From: Amanda Scholes on behalf of Planning.Responses
Sent: 30 November 2021 09:30
To: Planning Scanning
Subject: FW: Dappers Lane - Drainage- OWC application
Attachments: LDC-ARUN-2021-017 1c OWC Approval letter (1).pdf; LDC-ARUN-2021-017 1c OWC Consent.pdf; A360 - 09 C Offsite Drainage Works.pdf

Our ref: LDC/ARUN/2021/017

RE: Land Drainage Works – Development at junction of Water Lane & Dappers Lane, Angmering

PERMEABLE BLOCK PAVED CAR PARK & DISTRIBUTION TANK DETAIL

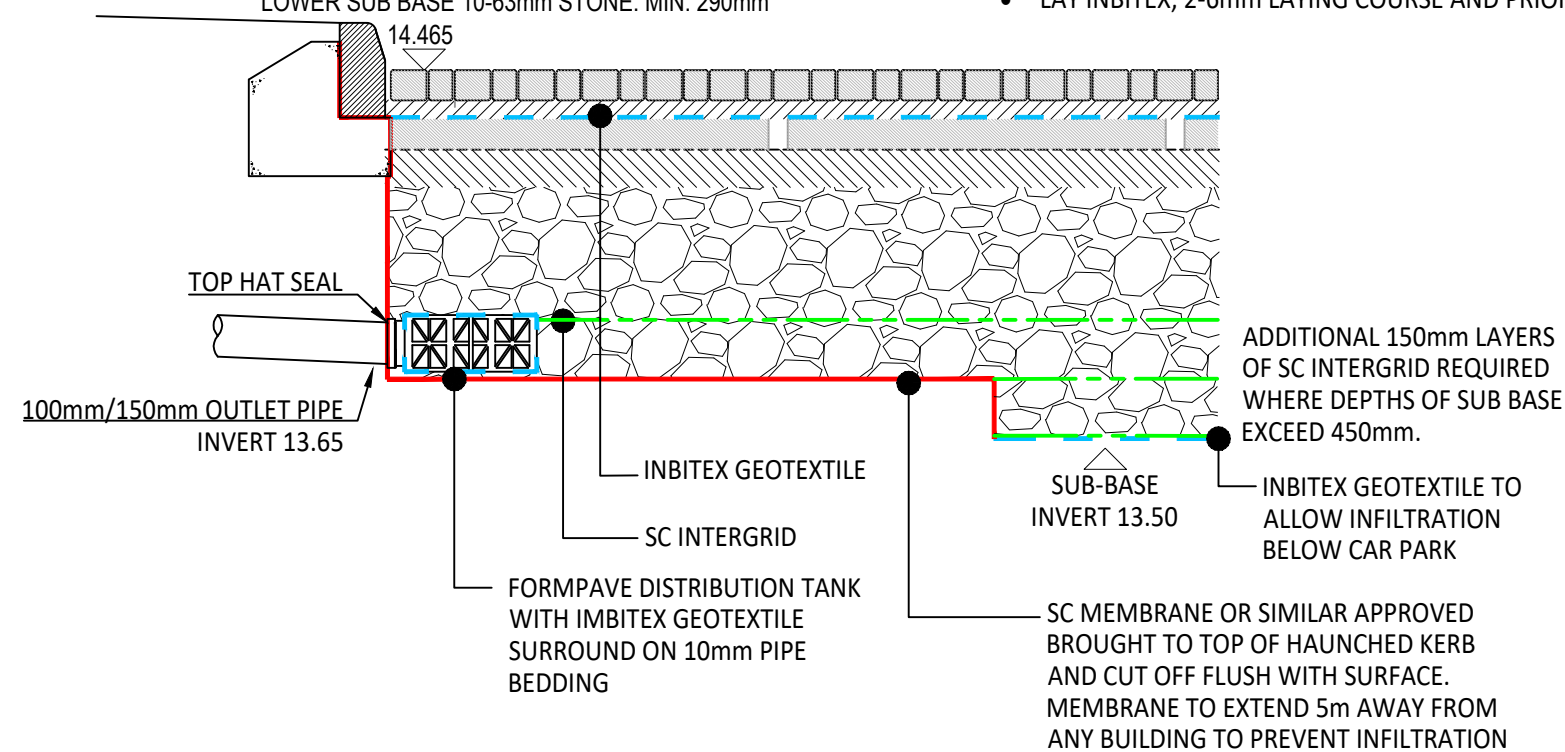
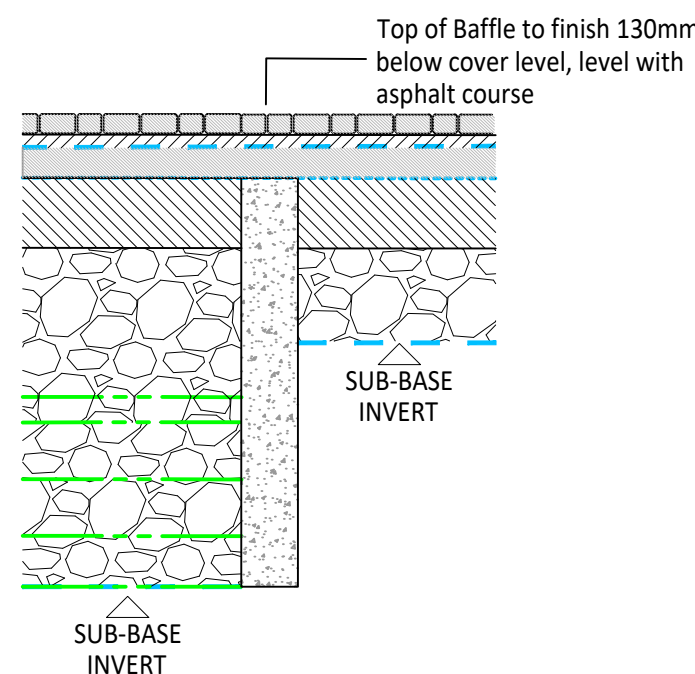
6. A construction detail drawing of the permeable paving is required. Including additional details showing diffuser block connections, and baffles. *Detail showing distribution tank does not appear to have been supplied. Awaited*

7. Please provide construction detail of permeable paving which is shown to not have a permeable sub-base. *Is this shown by the area with the SC membrane on the permeable block paved car park detail?*

ACO SWALE INLET DETAIL

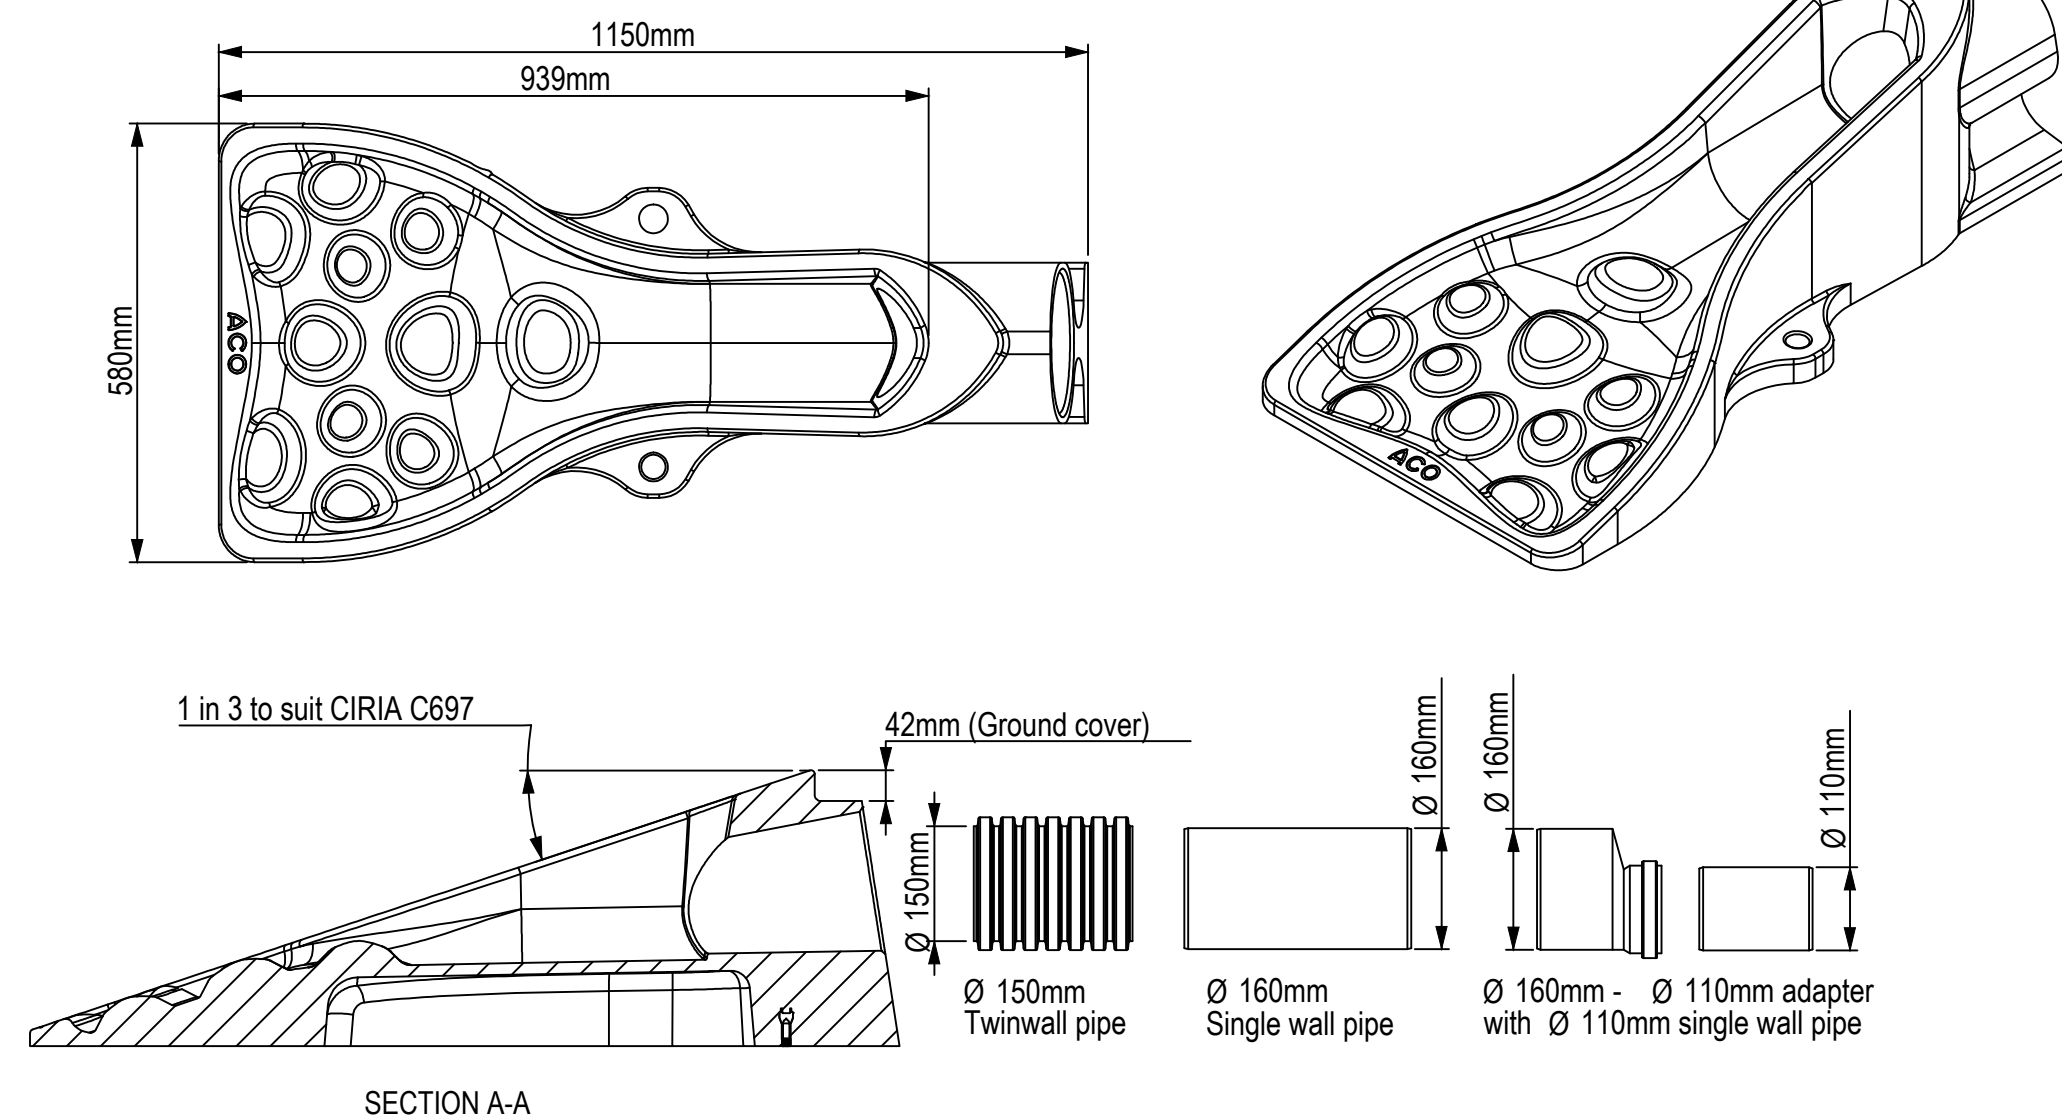
5. Please provide construction detail drawing showing swale cross section, long section, ACO inlet detail in relation to swale, connection between swale and ditch. *Await comments regarding proposed connection to ditch from a land drainage consent perspective.*

TYPICAL BRICKWORK HEADWALL

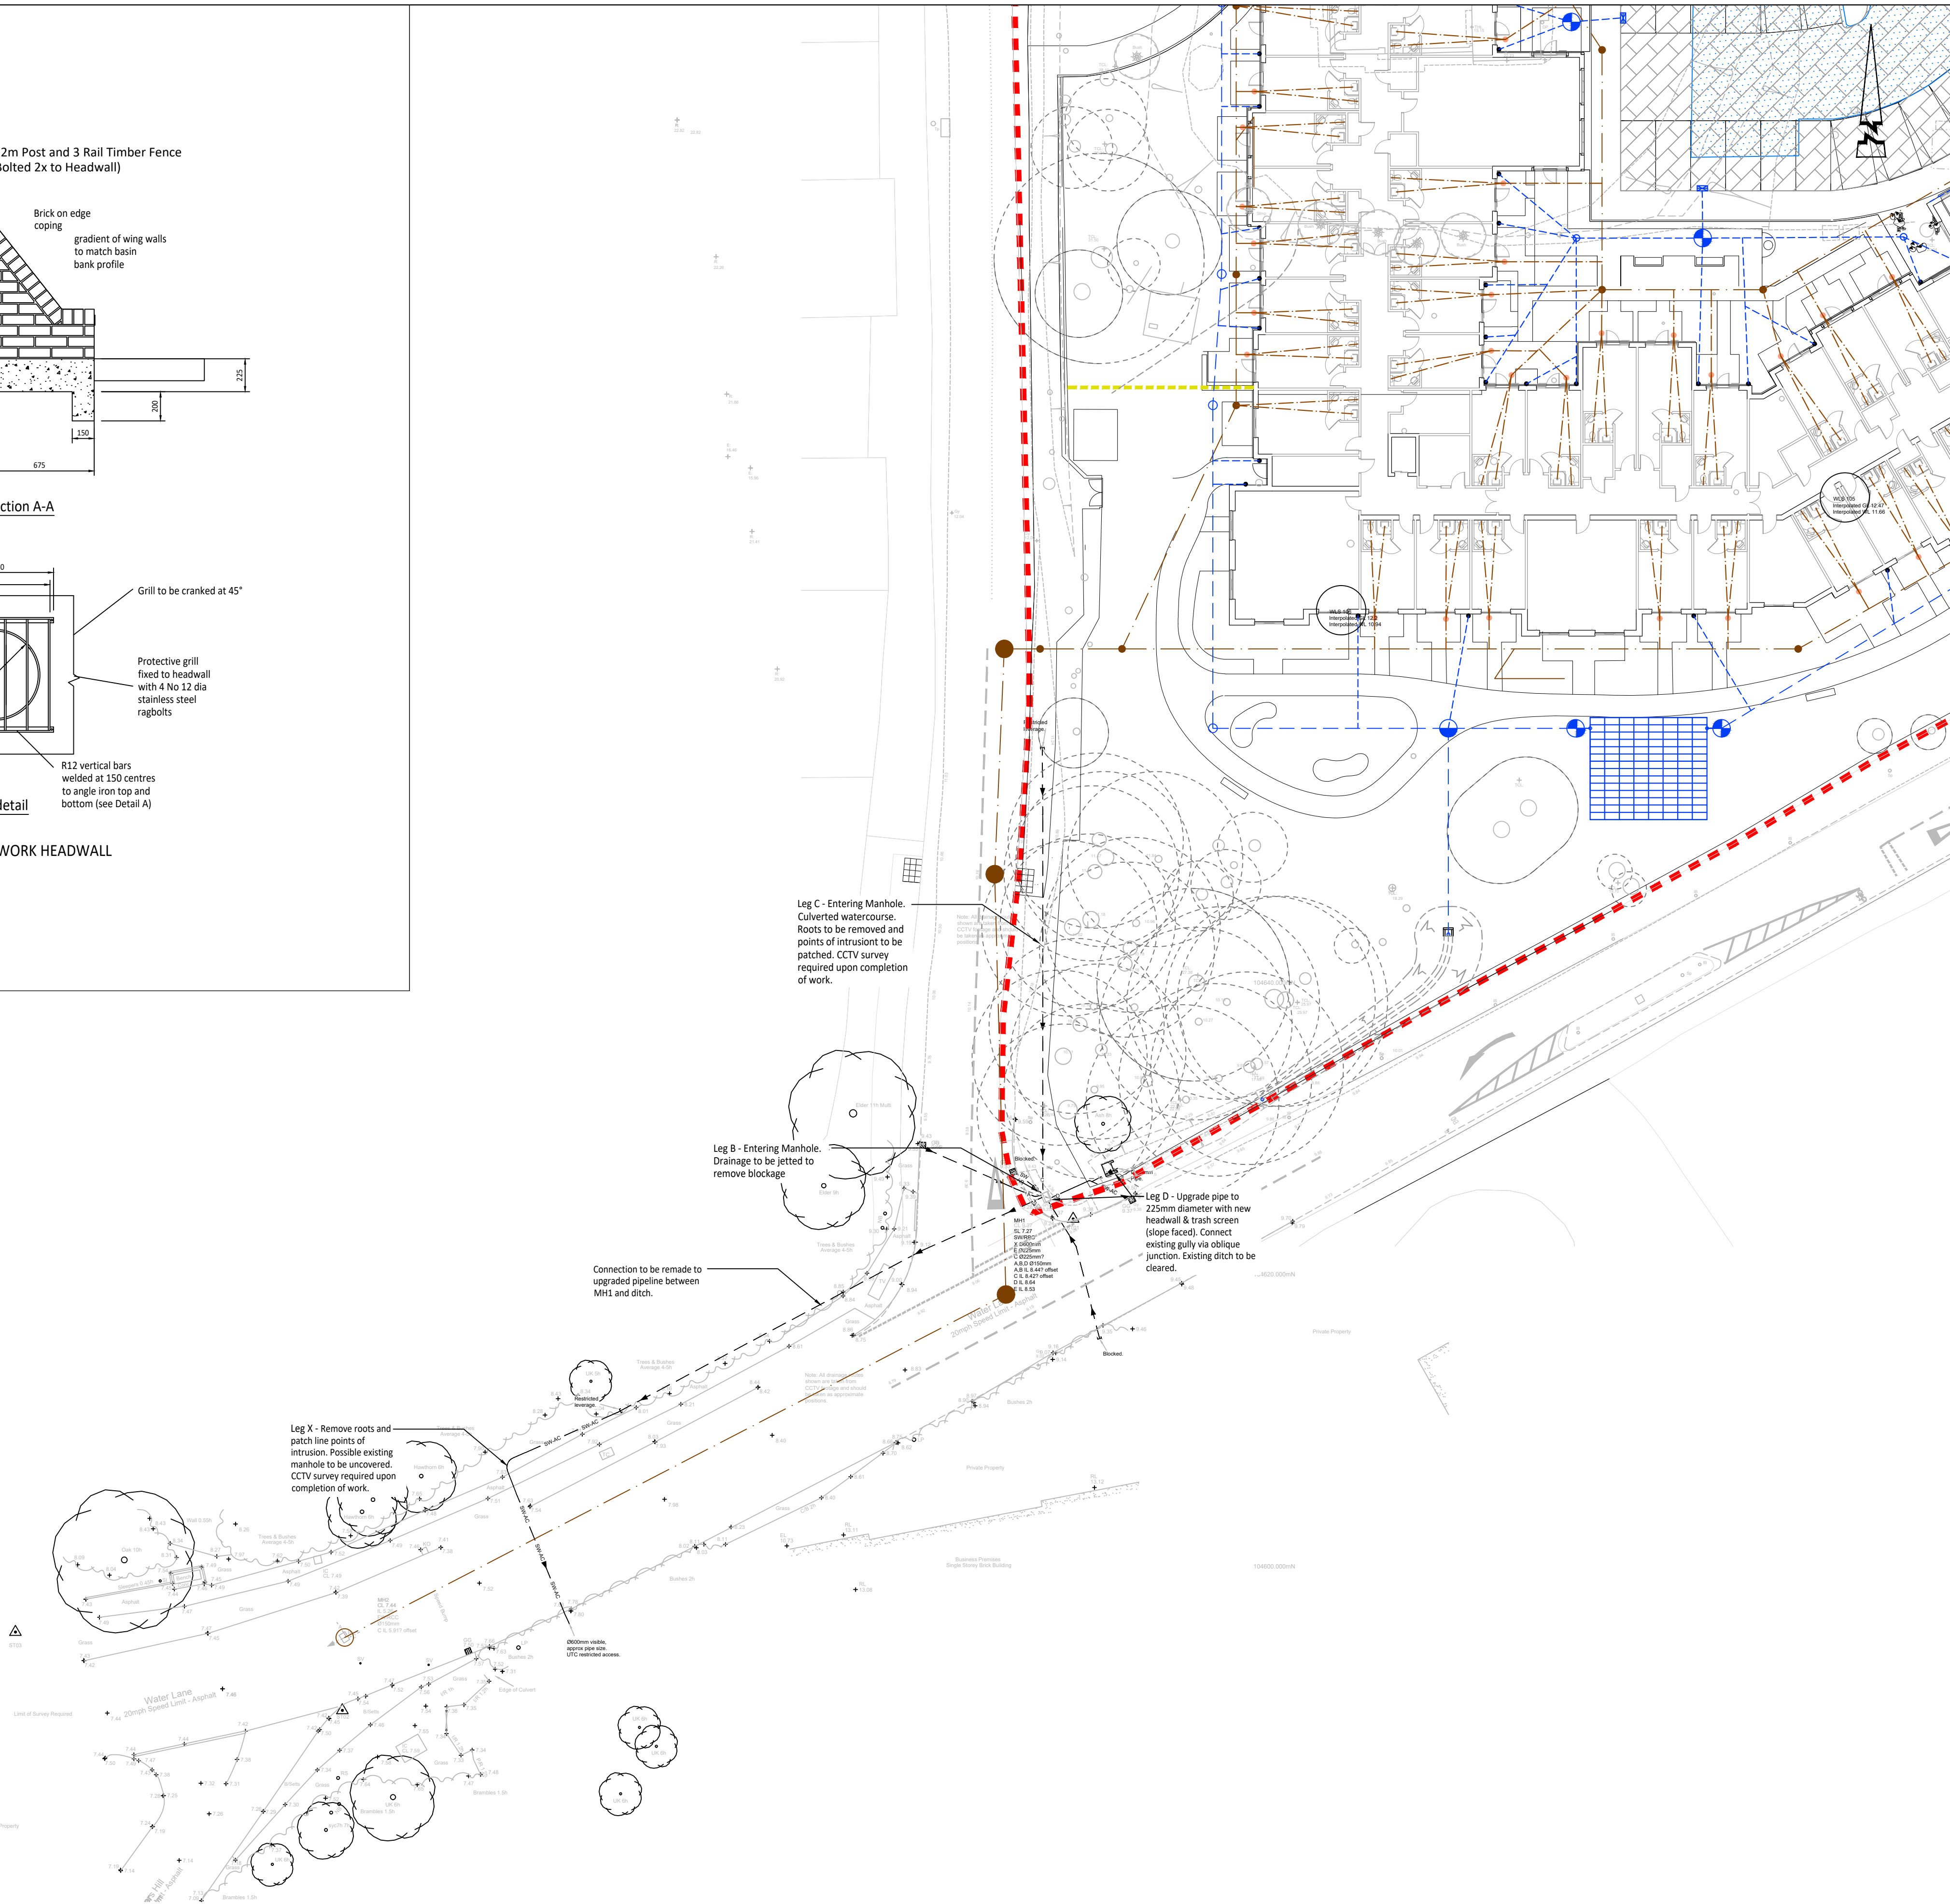
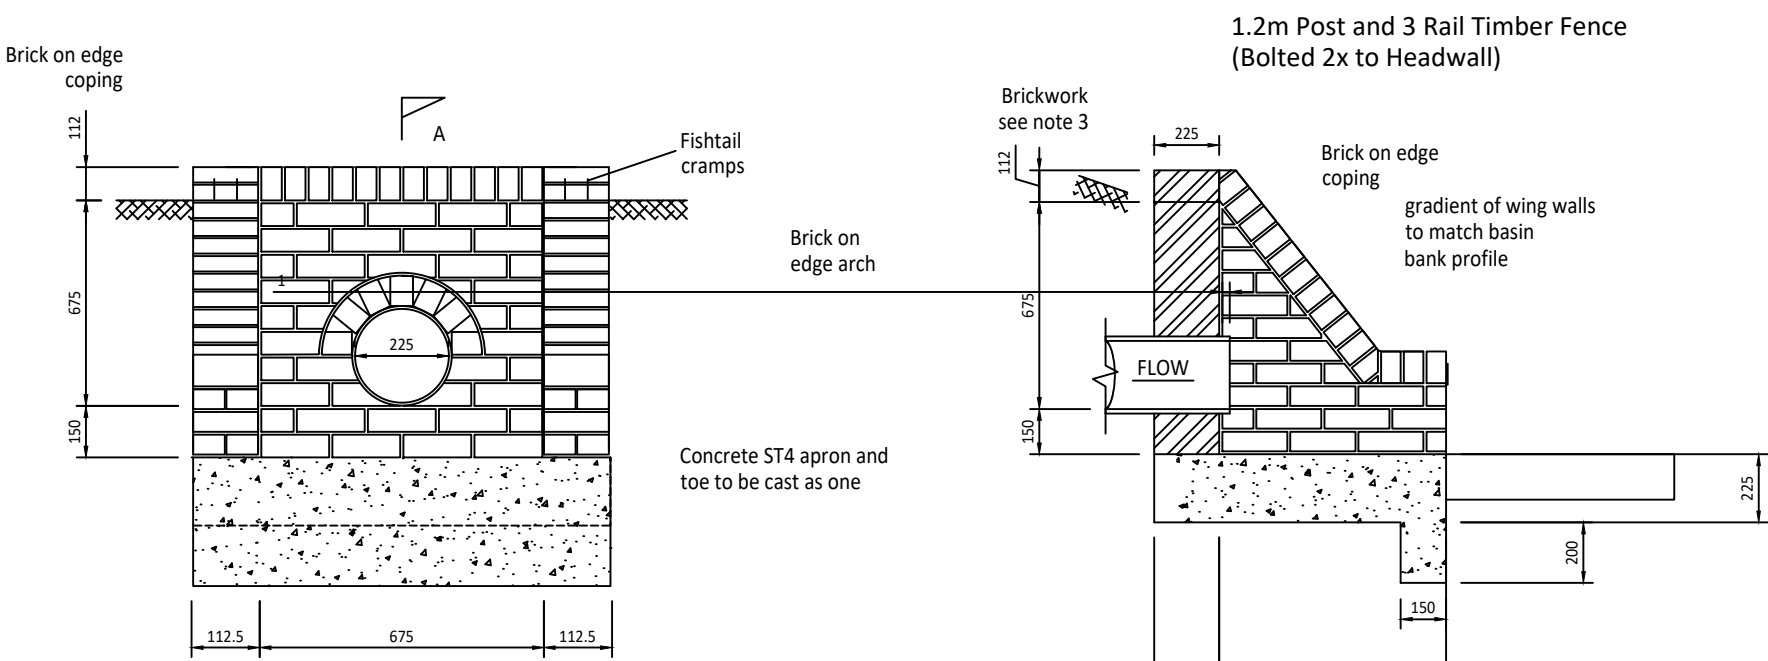
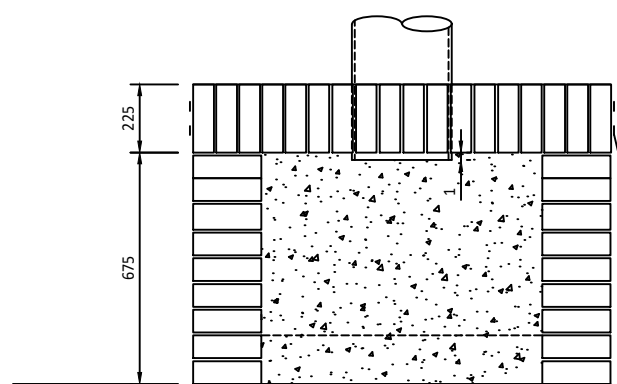
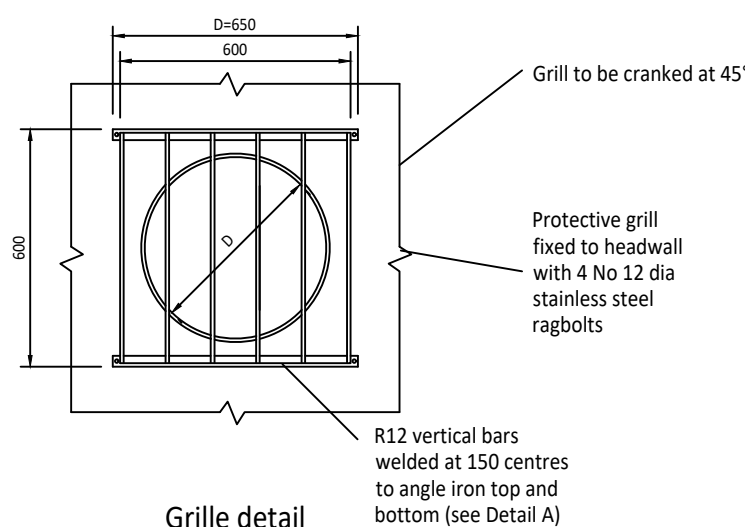
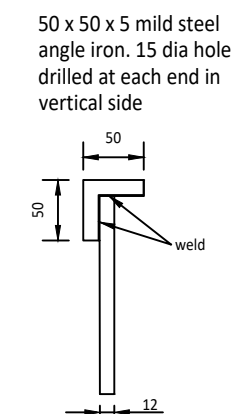
3. Please could you colour the culverts/ditch on the offsite drainage works plan to make them clearer. ok
4. Proposed headwall & Leg 'D';
 - a) Specify invert levels of proposed 225mm pipe. ok

- b) Brickwork refers to note 3 but should be note 2. Prefabricated headwall now specified as discussed. Specify the manufacturer and model, to suit the 225mm pipe.

- c) Show how the post & rail fence will be bolted to the headwall. Prefabricated hand railing now specified. ok
 - d) Please adjust the proposed trash screen design to utilise this one or very similar; 225mm Sloped Trash Screen with Sides 45 degrees | Althon Specify the 45 degree trash screen in association with 4b)

- e) Entry into existing manhole – make good manhole wall as necessary – add note. ok
 - f) All pipework to be twin walled polypipe or similar approved with 150mm thick ST4 concrete bed and surround with expansion joints. Add suitable note/detail. See enclosed drawing to assist.

5. Gully connection – existing lateral to be joined to new pipework/oblique junction using a 'flexible' coupling – add note. Remove the saddle connection detail as this is not applicable.

6. Leg 'B' - proposals noted thank you. -
7. Leg 'C' – proposals noted but ensure entire length of culvert adjacent the site boundary is shown. ok
8. Leg 'X' - Undertake further CCTV survey to enable completion of previous survey to Black Ditch – Present findings so further discussions can be had. Relevant notes added to plan. ok

9. Note 'Connection to be remade to upgraded pipeline between MH1 and ditch' shown in wrong location. ok
